SSD6724 – Mixed Use Student Accommodation Development at 60-78 Regent Street, Redfern

The following pages responds to specific points made in their response to submissions. Red indicates extracts from [2015-03-18 Response to Submissions_ Iglu Student Accommodation Redfern.pdf](#)

Figure 12 – Illustrative representation of directed-views from proposed bedrooms with angled window hoods

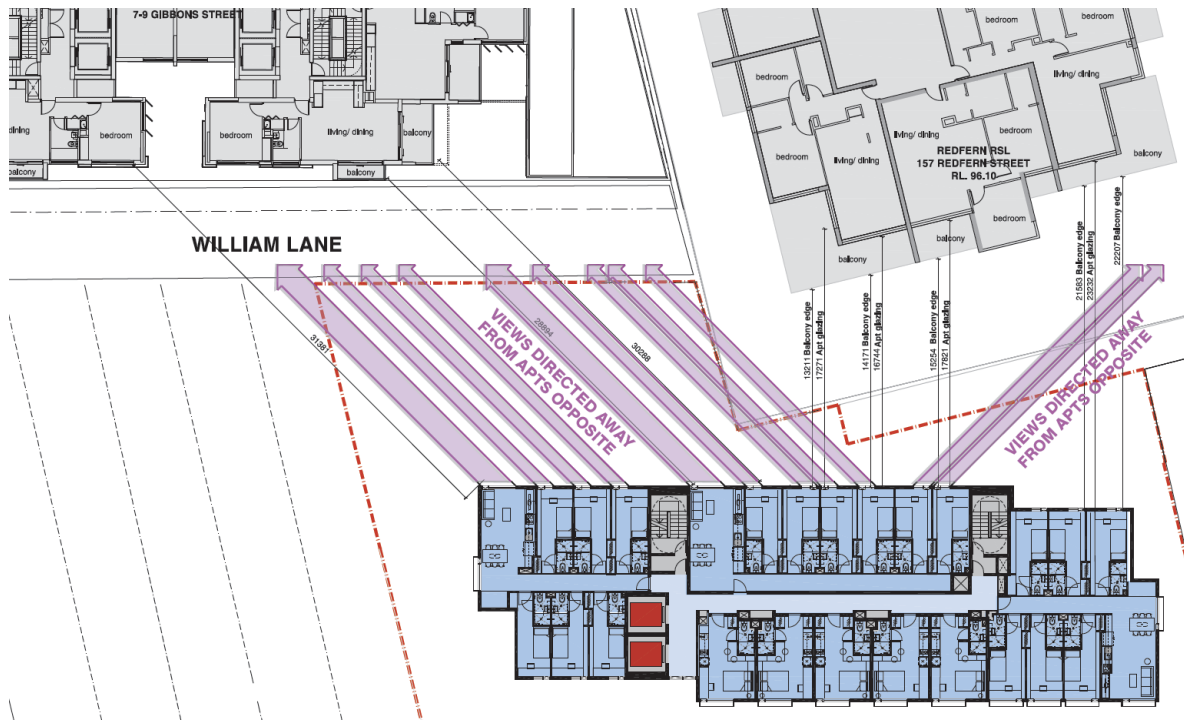
The only solution to the most major issue, privacy, is woefully inadequate. Adding a 30cm angled extension to the window will do nothing to lessen the invasion into neighbouring apartments. This above diagram assumes a person would only ever angle themselves at 45 degree to their window, and apparently be unable to look straight ahead.
